A417 Missing Link

ExA's Written Questions (ExQ1)

Response from: Cotswolds Conservation Board

Date: December 2021

Drawing Title: **FIGURE 13.19 SCHEME HIGHWAY DRAINAGE - PLAN**

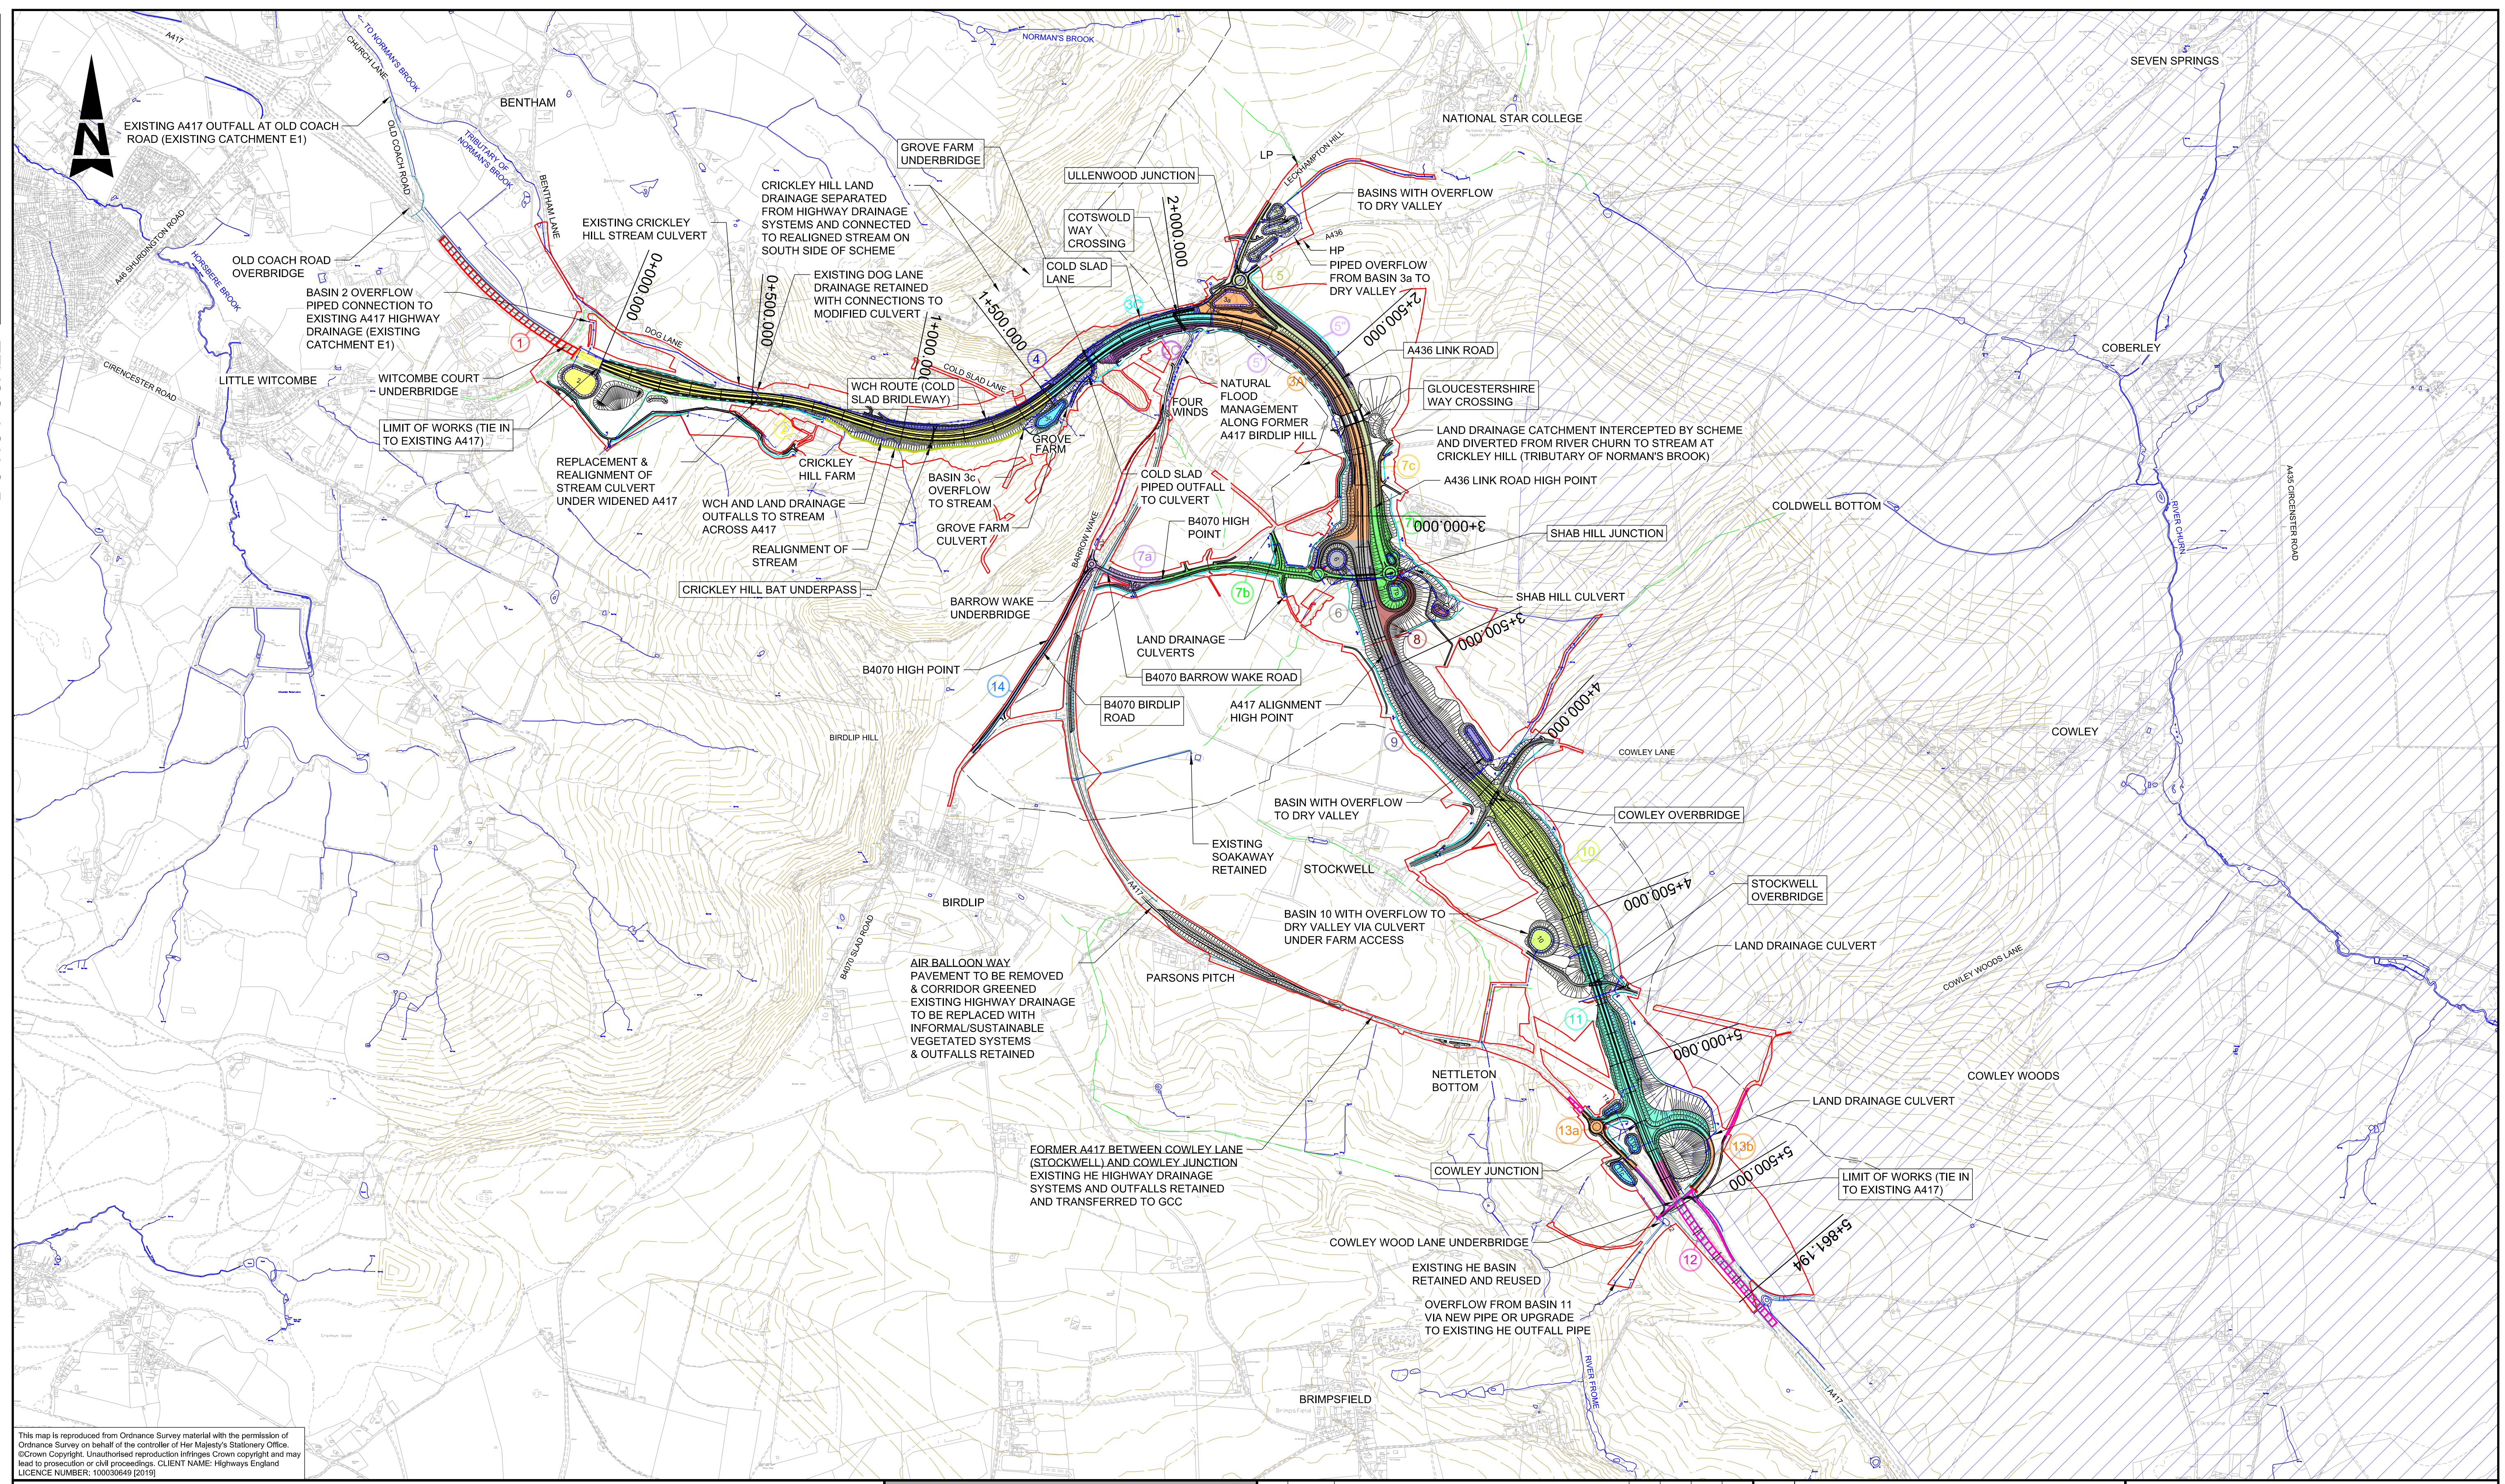
<p>Draft Development Consent Order 1.5.15</p>	<p><u>DEEMED CONSENT (ARTICLES 15, 19, 21, 23)</u>: There are a number of articles which contain deemed consent provisions, i.e. if the consenting authority does not respond within a certain time consent is deemed to be granted. Are the consenting departments happy with these provisions and the timescales set out?</p> <p>Response: The Cotswolds Conservation Board is not the 'consenting authority' with regards to Articles 15, 19, 21 or 23 of the draft Development Consent Order. As such, we do not consider that this questions relates directly to the Board. It is worth noting that the Cotswolds Conservation Board does not own any land, building or infrastructure.</p>
<p>Landscape and Visual 1.8.6</p>	<p><u>ATTENUATION FEATURES</u>: a) A number of attenuation features are proposed in the Order land. Do you consider the number, design and layout of these to be compatible with the special qualities of the AONB? b) If yes, how and why? c) If not, why not and what are the implications?</p> <p>Response: The proposed attenuation features have not been a key consideration for the Cotswolds Conservation Board to-date. However, having reviewed the information relating to the attenuation features, we would like to make the following comments:</p>

<ul style="list-style-type: none"> • Features such as drainage basins are not a characteristic feature of the Cotswolds AONB landscape. • Overall, the eight drainage basins would not be compatible with the landscape character of the relevant landscape character types and special qualities. • In terms of visual impacts, most of the drainage basins would be seen from adjacent roads and public rights of way. • However, they would not be particularly noticeable in long distance views, except when they are full of water. • Tree planting and local topography will help to reduce the visual impact in some cases. The most visually prominent drainage basin (in the long term) is likely to be the relatively large basin at the west end of the scheme. <p>It is worth noting that, in all cases, the drainage ponds will be directly adjacent to the A417 (and, in some cases, adjacent to additional infrastructure). In the context of the overall road scheme, the drainage basins are likely to have a relatively minor adverse landscape and visual impact in the long term. As such, they are a relatively minor issue with regards to the effects of the scheme on the natural beauty of the Cotswolds AONB.</p>
